11 November 2010

The General Manager
Randwick City Council
30 Frances Street
Randwick NSW 2031

Re: Objections to Proposal to Redevelop Stabling DA 871/2010

ELEVATIONS - STABLE BLOCK
 STABLES & TRAINING FACILITIES
AJC RANDWICK RACECOURSE

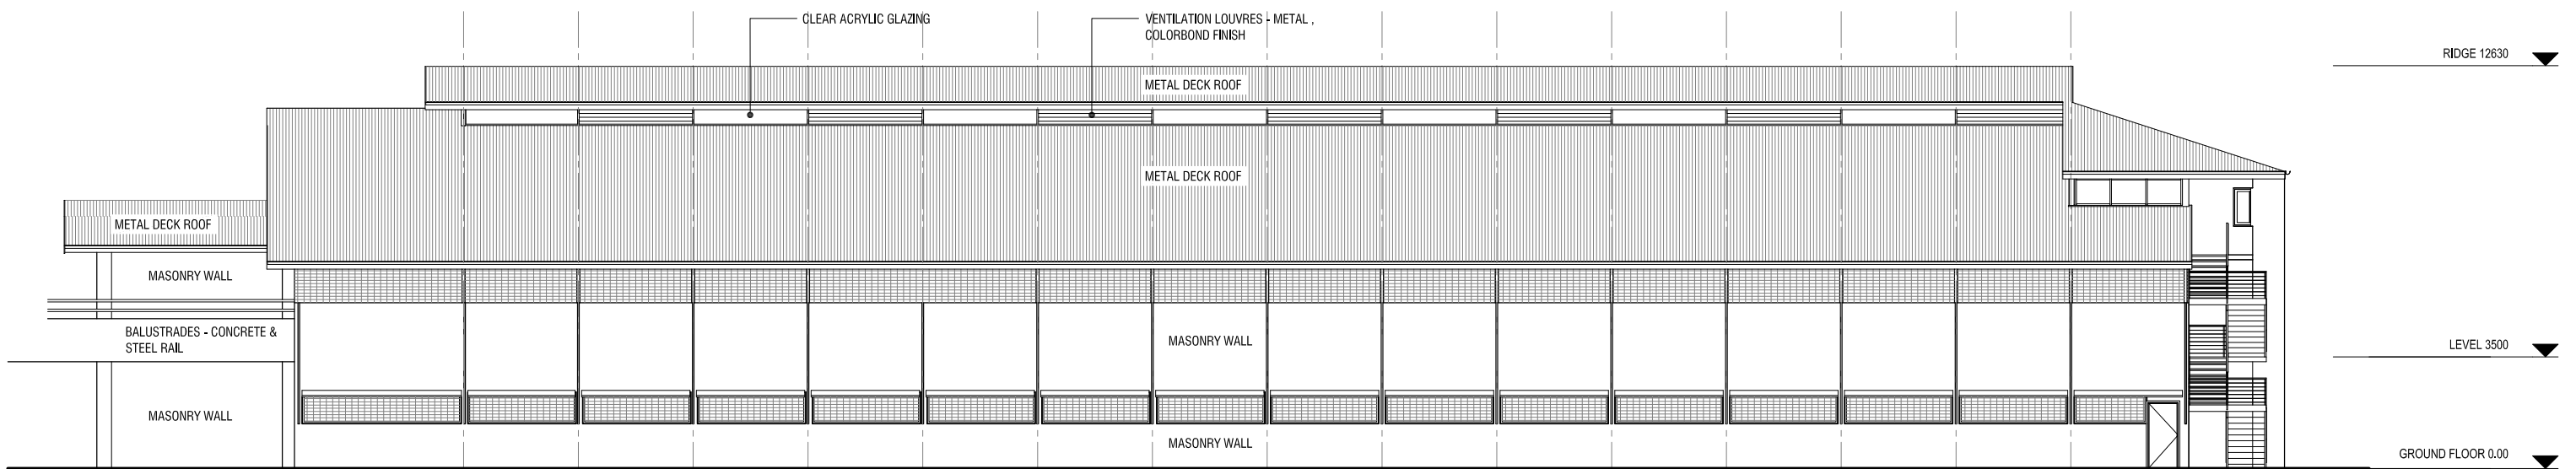
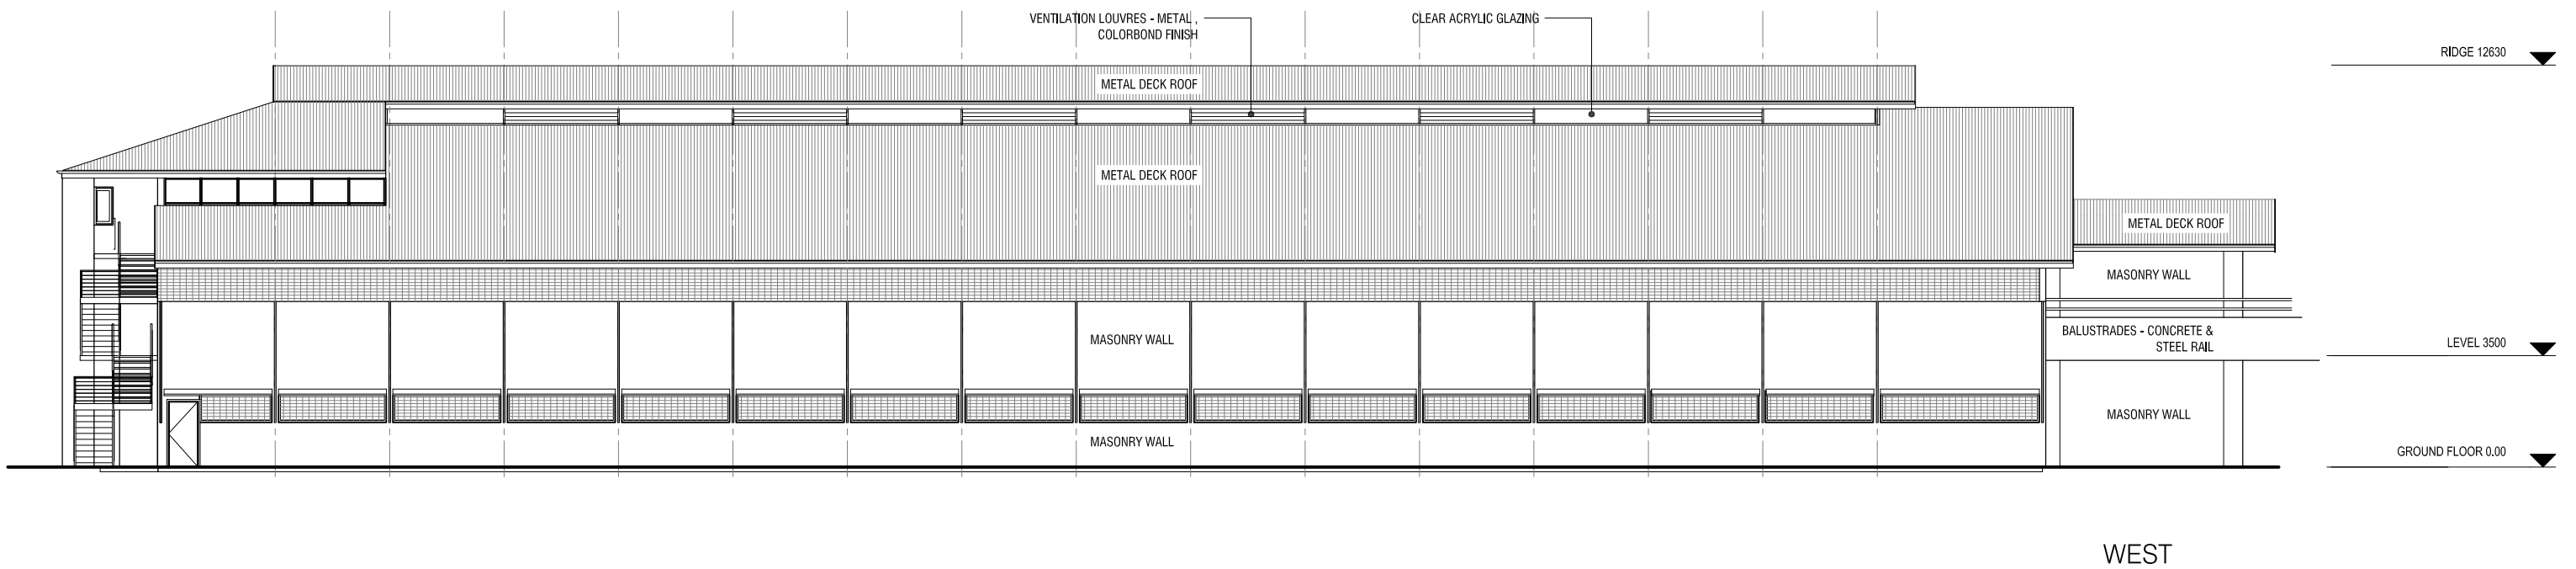
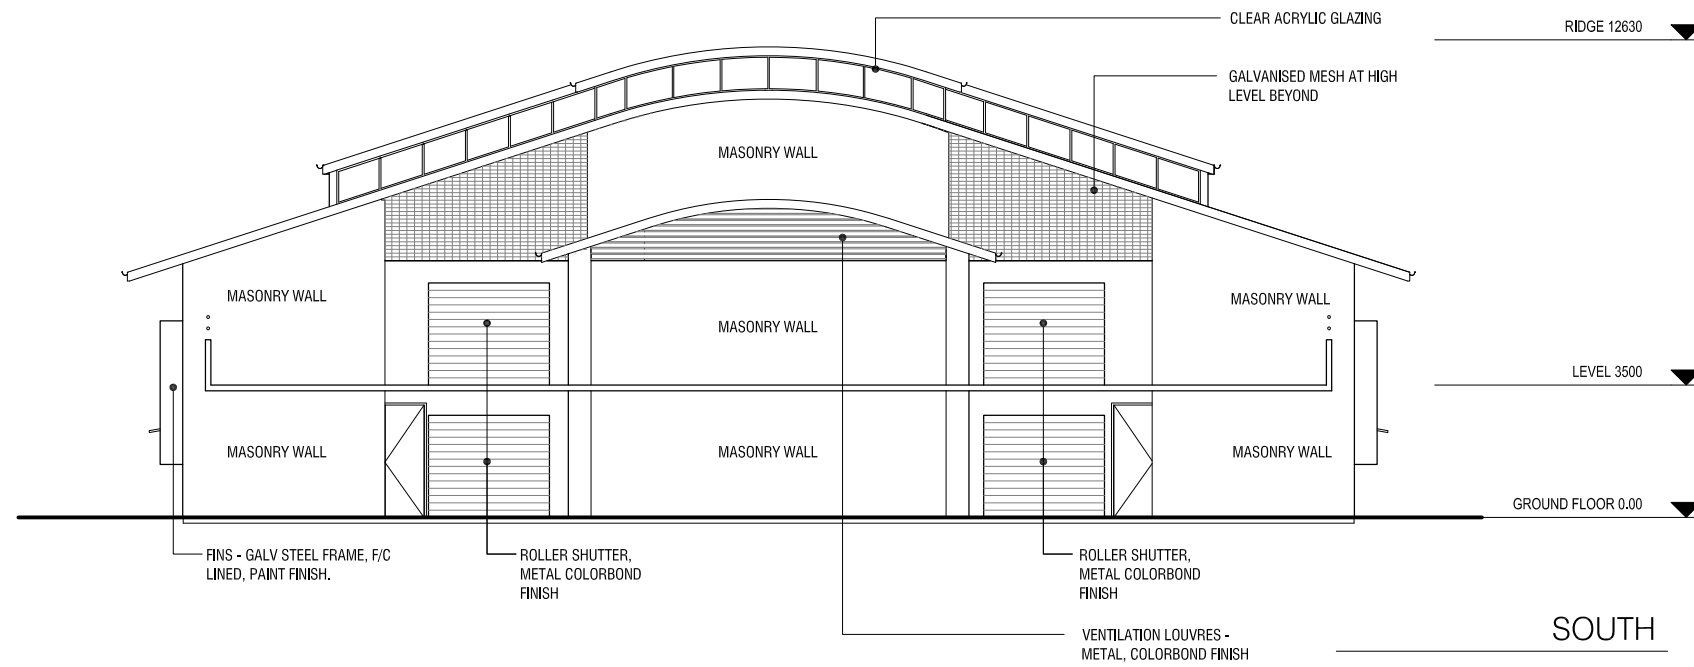
We feel that the proposed height of the stable complex is too high and would adversely affect the aspect across Wansey Road and Alison Road. A far more sensible plan would be to make the stable blocks single storey (bearing in mind that in this case "single storey" is closer to two residential storeys in height) and have more blocks that move further up Wansey Road, hugging the hillside. This would be much more discreet. We were surprised to see in some presentations that the supposedly showed the minimal visibility from adjacent houses where in fact the photos were taken from the first floor of an already high house which sits on top of the equivalent of at least one storey of sandstone. This may not have been intended to be misleading but it definitely did not show the perspective as it would be seen by local residents. I do concede that the further north you go up Wansey Road the lesser the visibility impact but we have to consider the merits of the development as a whole, I believe.
